From: Julie Baxter
Sent: 17 May 2022 13:03
To: Andrew Lewis
Subject: RE: 22/00747/OUT - Land at Bicester Road, Kidlington

Overview of the Outline Application:

Illustrative Landscape Strategy Plan and Development Framework Plan:

Figure 4.3: Land Use Plan

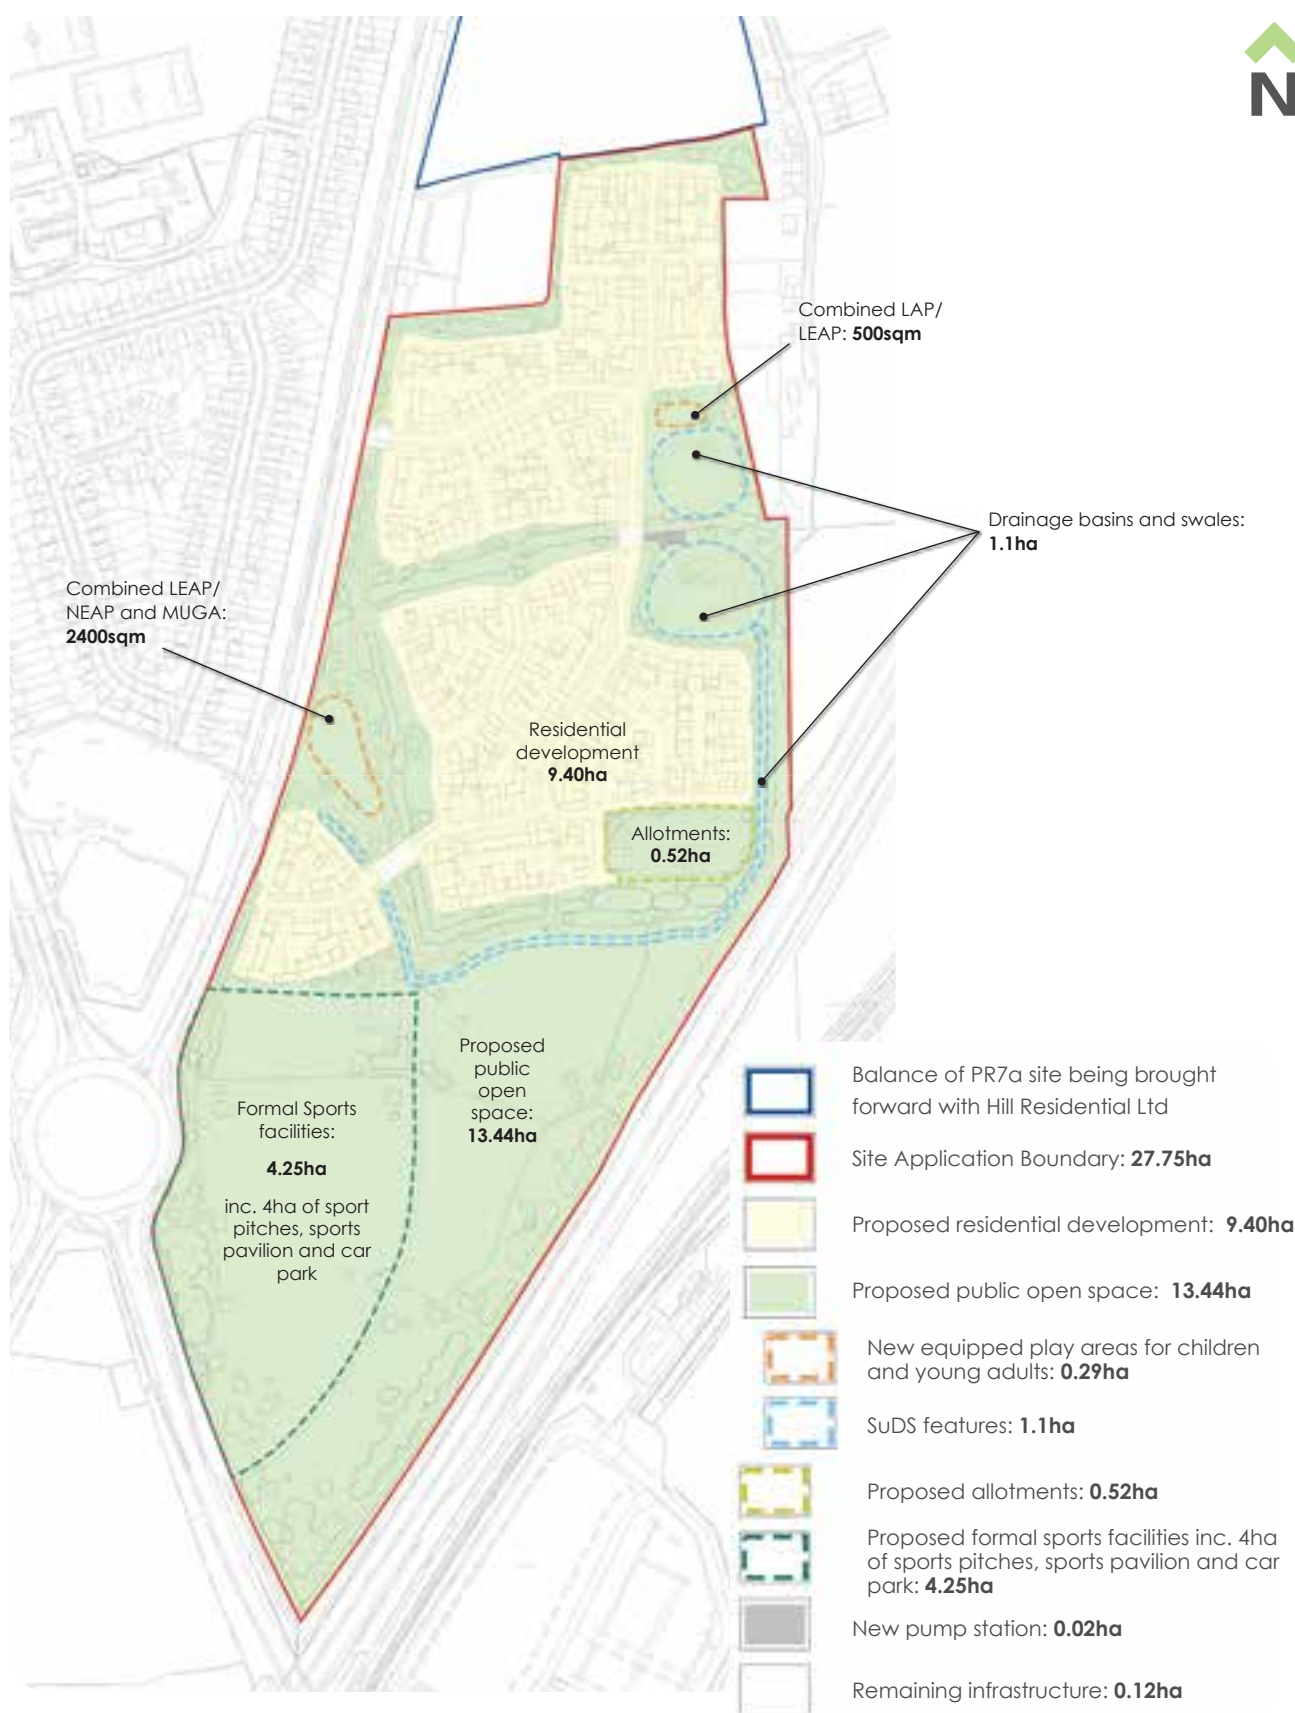
We will need to see a strategy for the location of these. The combined LAP / LEAP should be located within the housing areas so they can be accessed easily and can be overlooked. Play facilities can provide valuable open space within housing areas. Central LAPs and LEAPs provide facilities within safe easy walking distance and break up the built form.

Locations of both play areas are either close to an existing pond or a proposed SuDS basin. Although the SW combined play area has been located close to the proposed 'Greenway' and a secondary pedestrian route, the viability of the location needs to be taken into account with the retention of the existing vegetation which could reduce the amount of visual surveillance also taking into account the distance from the proposed residential areas.

Ensure that adequate parking is provided (at least one parking space for every two plots). Design and layout needs to ensure that the location of the parking for the allotments and pavilion are kept separate to avoid allotment allocated spaces being used by those using the sport facilities. Suggested that allotments are to be divided into half plots of 5 or 125 sq. m. Plot numbers and parking spaces need to be verified.

- Quantitative standard: 0.37 ha per 1000 people with a 10 minute walk (800m). Does the allocated 0.4ha exclude / include the area provided for car parking?

The existing pond will need some form of protective fencing to discourage dogs and pedestrians from encroaching onto the marginal zones and into the pond itself. Currently this area is shown to be constrained by the play provision minimum area requirements:

Activity Area LEAP/NEAP/MUGA = 2,400m² (400+1000+1000)
Landscape Buffer 13,950 m² (3200+7500+3250)

It may be a consideration to relocate this play provision to the southern part of the proposed development (where the informal kickabout area is shown) but still located as close to dwellings as possible to meet the min. distance criteria.
